On Tue, 2 Dec 2025, 18:51 Stephen Fox, [REDACTED] wrote:
TO: The Examining Authority **PROJECT:** One Earth Solar Farm
(EN010159) **FROM:** Stephen Fox (Interested Party Ref: [REDACTED]) **DATE:** 02.12.25

Please accept this as a submission for deadline 6.

Technical Critique of Environmental Statement Appendix 7.2: Flood Risk and Water Management Strategy (One Earth Solar Farm - EN010159)

Figure 1.3: Cross-section of typical HDD construction method ⁴

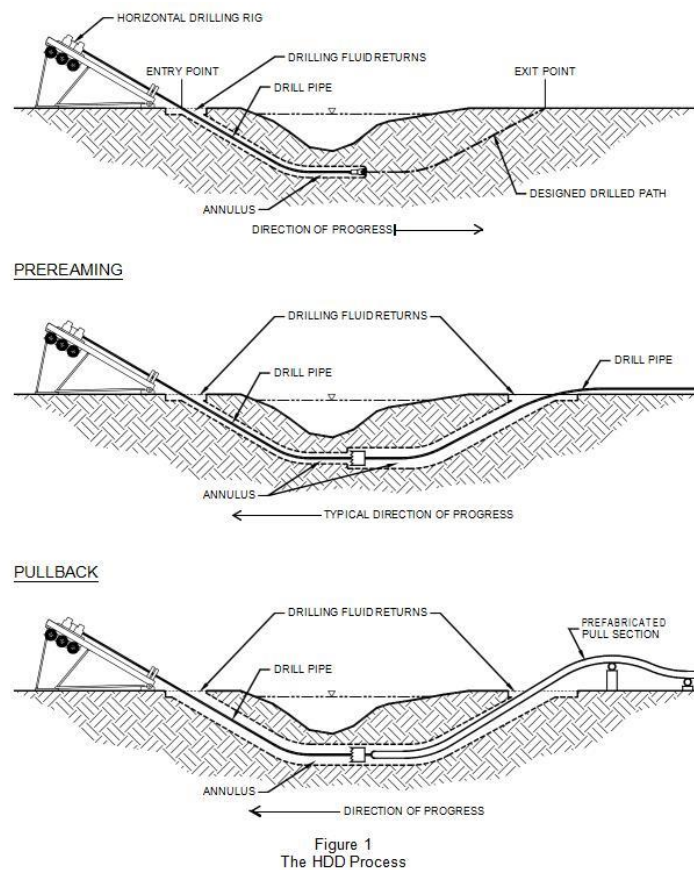
The Applicant's WRA currently lists construction demands but explicitly excludes "Volumes of water required for horizontal directional drilling fluids (bentonite clay mixing)."³ This is a fundamental oversight. HDD is a hydro-mechanical process that relies entirely on drilling fluid (mud) to:

1. **Stabilize the Borehole:** The hydrostatic pressure of the fluid prevents the borehole from collapsing, particularly in the soft "Older River Deposits" (sands and gravels) found at the site.⁷

To demonstrate the materiality of this omission, we must calculate the potential water demand. While the exact bore length for the river crossing itself may be shorter than the full 4.38km route, the cumulative drilling required for the river and associated approaches is significant. The volumetric example below is conservative and useful, but it highlights the need for the Applicant to convert this into a **formal demand profile** tied to the actual number of bores, bore diameters, and construction schedule in the DCO application to quantify peak abstraction rates for licensing.

Drilling fluid is typically composed of 95-98% water and 2-5% bentonite clay.¹² The volume of fluid required is a function of the borehole volume and a "washout factor" or circulation factor (typically 1.5 to 3 times the hole volume to ensure hole cleaning).

- **Assumptions for Calculation:**
 - **Bore Length:** Conservatively assume the river crossing and immediate approaches constitute **1,000 meters** (1 km) of HDD work.
 - **Bore Diameter:** For high-voltage export cables, a bundle is often pulled, or multiple ducts are installed. A typical bore diameter for this scale might be **24 inches (0.6 meters)**.
 - **Annular Volume:** $V = \pi \times r^2 \times L$
 - $V = 3.14159 \times (0.3)^2 \times 1000 = 282.7$ cubic meters per bore.
- **Fluid Circulation Requirement:**
 - HDD operations typically consume fluid at a rate of 2-3 times the hole volume due to losses into the formation, surface spillage, and recycling inefficiencies.
 - **Total Fluid Volume:** $282.7 \times 3 \approx 848$ cubic meters (848,000 liters) per bore.

If the project requires multiple ducts (e.g., separate bores for different circuits), this number multiplies. For a project of 740MW, multiple circuits are a certainty. A conservative estimate for the total HDD water demand could easily exceed **2,000 - 3,000 cubic meters (2-3 megaliters)**. This is not a trivial volume that can be absorbed into a "petty cash" water budget.

- **Hardness/Salinity:** Hard water or saline water inhibits the swelling of bentonite, requiring chemical additives (soda ash) or significantly more bentonite to achieve the required yield point and viscosity.¹³
- **Source Implications:** The Applicant cannot simply pump raw water from the

River Trent (which is tidal and potentially brackish/turbid) without treatment or testing. If the river water is incompatible with the drilling mud chemistry, they will require potable water tankered in or a high-quality abstraction source.
